## City of Albuquerque Stormwater Construction Site Inspection Report

General Information				
Project Name:	Generations @ West Mesa			
Location:	5710 Avalon Rd NW			
Site Contact Name & Agency	Joe Cocchina/ Ben Marshall	ESC File No.	K11E084	
	Gorman Company Inc.	NPDES Id. No.		
Inspection Date:		Start/End Time:		
CoA Stormwater Inspector:	Timothy Sims, Stormwater Inspector			
Present Phase of Construction:	verticle with some utilities			
Type of Inspection:	<input type="checkbox"/> Regular	<input type="checkbox"/> Storm Event	<input type="checkbox"/> Post Storm Event >0.25"	<input checked="" type="checkbox"/> 311/Complaint <input checked="" type="checkbox"/> Follow Up

EROSION AND SEDIMENT CONTROL PLAN

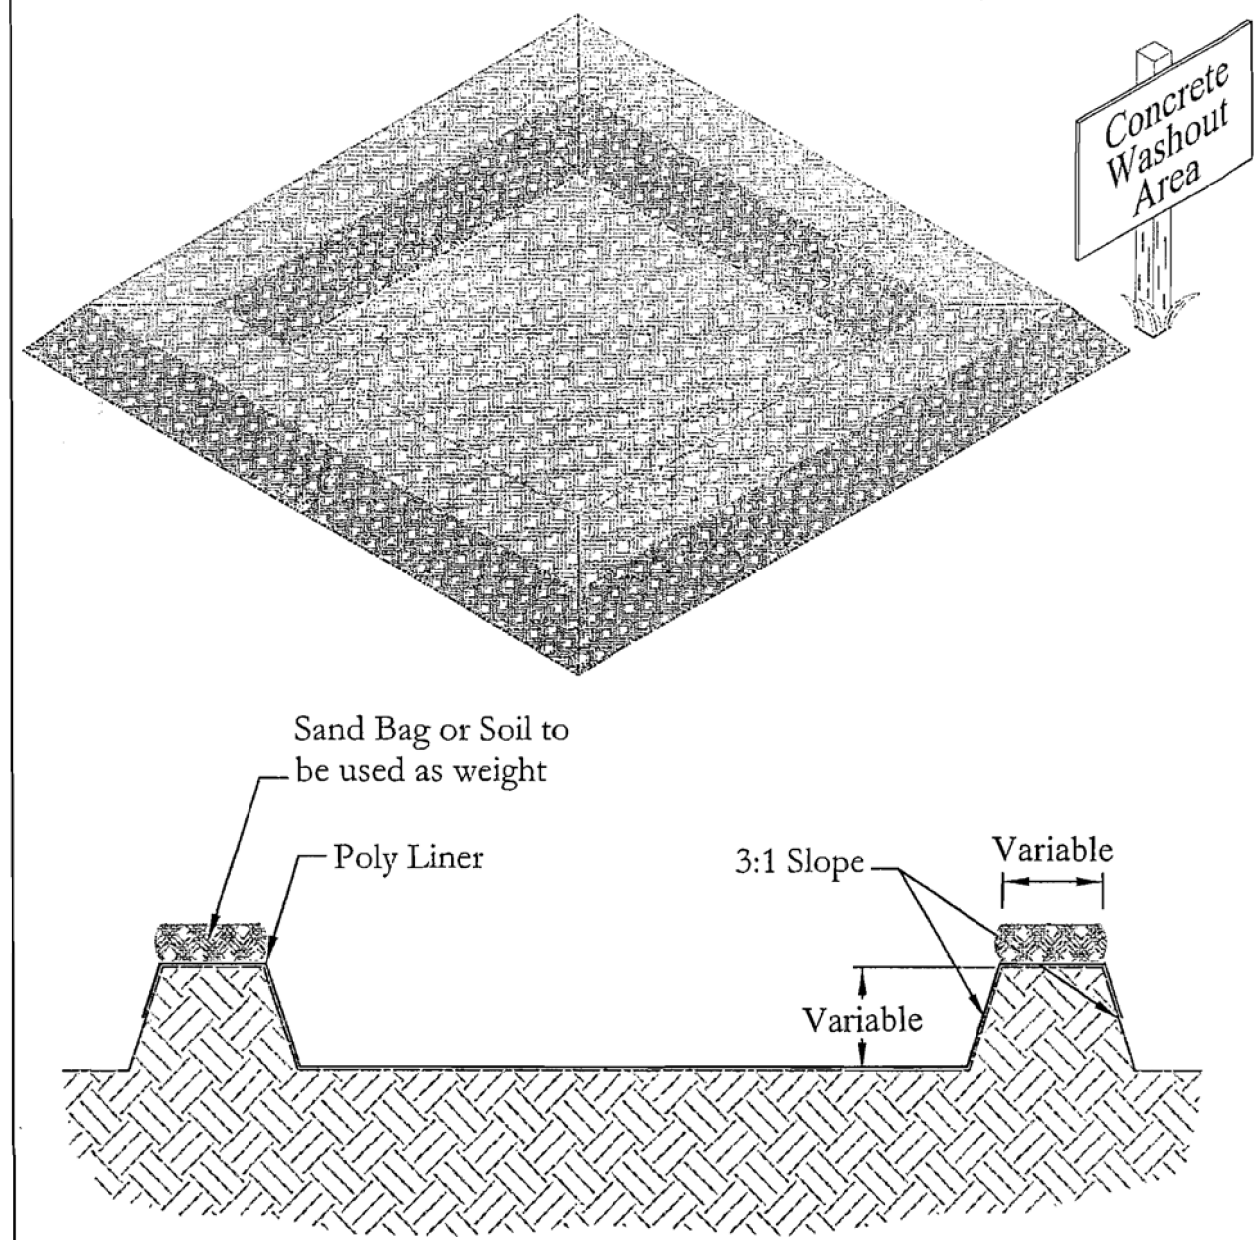
2.2.3	Sediment control along any perimeter	x	provide sediment BMP at 57th St and Esperanza
2.2.3	Sediment control along any perimeter		
2.2.3	Sediment control along any perimeter

2.2.3	Sediment control along any perimeter		
2.2.3	Sediment control along any perimeter		
2.2.3	Sediment control along any perimeter		
2.2.4	Minimize sediment track out	x	clean 57th St of track out -Central to North of entrance

Notes:	for the size of this site all BMP installed are functioning well. Please provide much sock or silt fence (sediment BMP) on east entrance off of 57th St at Esperanza. Track out will require to be cleaned on 57th St from Central to Esperanza.
